Response to Planning Application

From: Arun District Council Greenspace

Application ref: FP/32/21/PL

Description: Two storey, 4 Bed detached dwelling with new access & parking. This site is in CIL Zone 4 & is CIL Liable as new dwelling

EXISTING PLOT PLAN

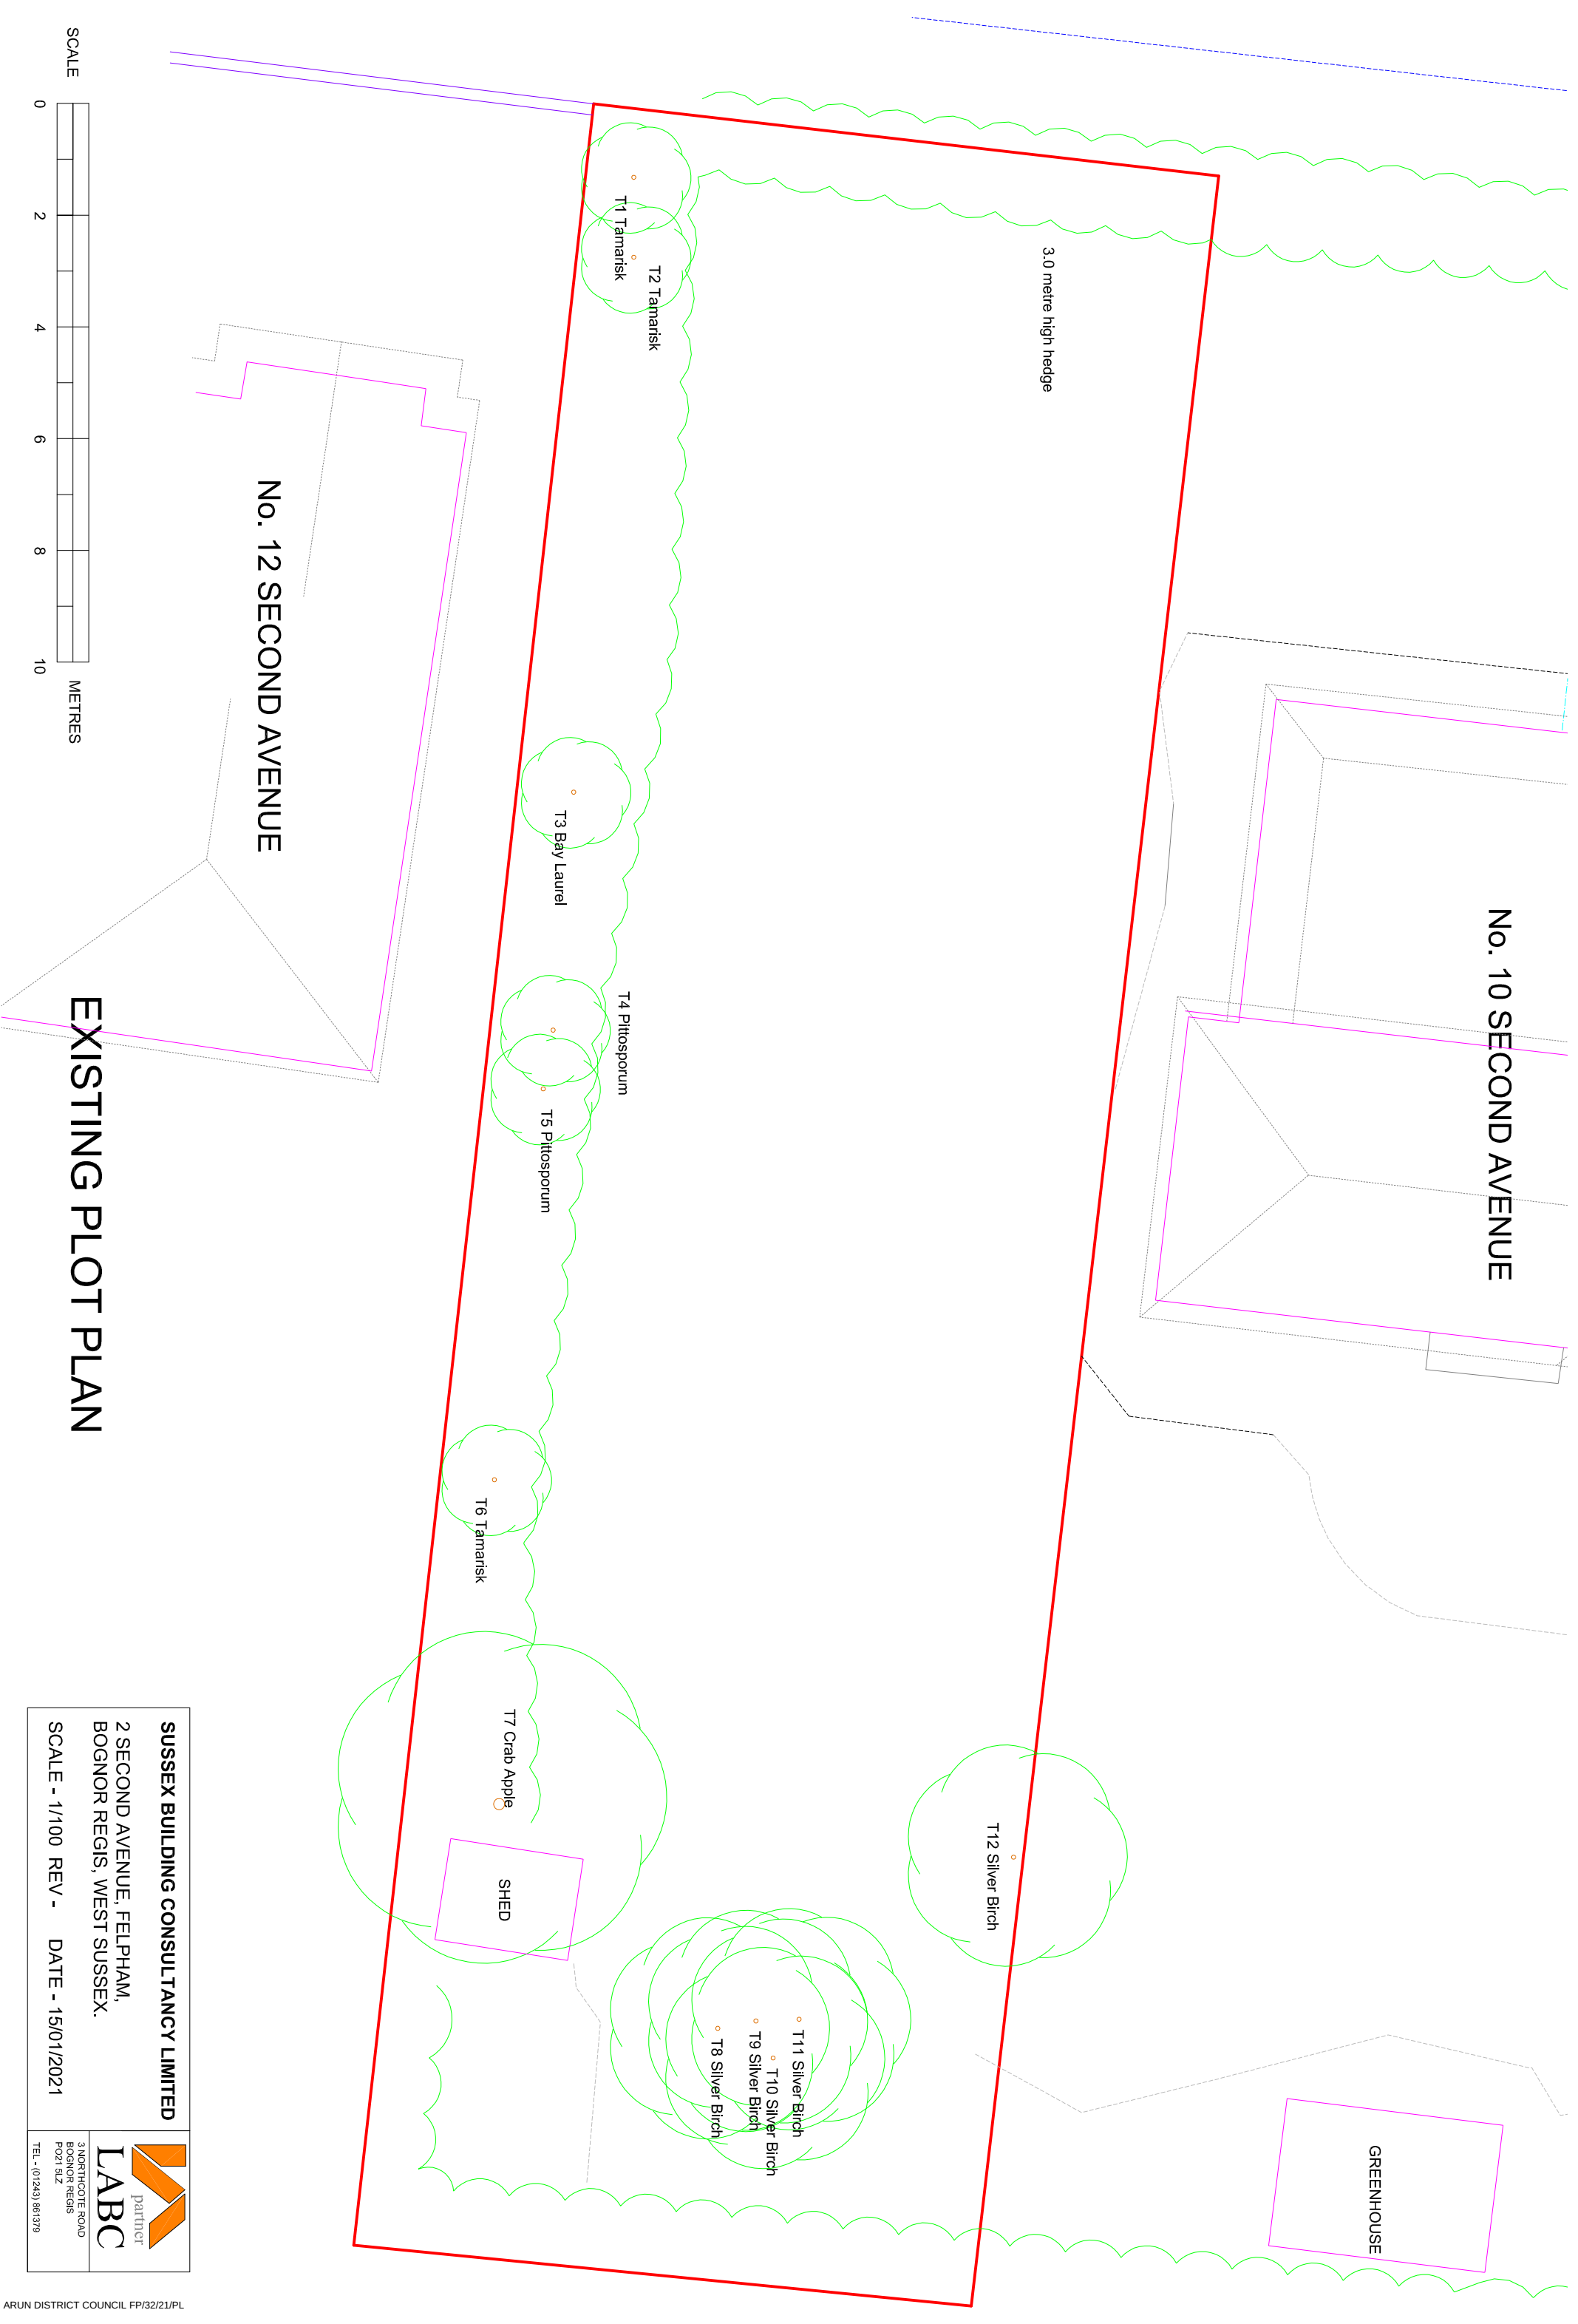
The NPPF para 124/127 and Arun Design Guide 2021, relate to good design principles which equally apply to small infill and replacement development. The indicative site layouts and tree protection plans has made

reference to indicative planting alongside tree retention. These details would require expanding in the form of a detailed planting plan and specification detailing species choice, actual plant quantities, planting densities and size at time of planting. Detail should also be provided regarding existing trees and boundary planting.

I would recommend no landscape objection to the proposals subject to submission of landscape details to provide ornamental and native improvements and potential biodiversity gain. To confirm tree protection methods in relation within and beyond the site boundary that may be affected by the development proposals.
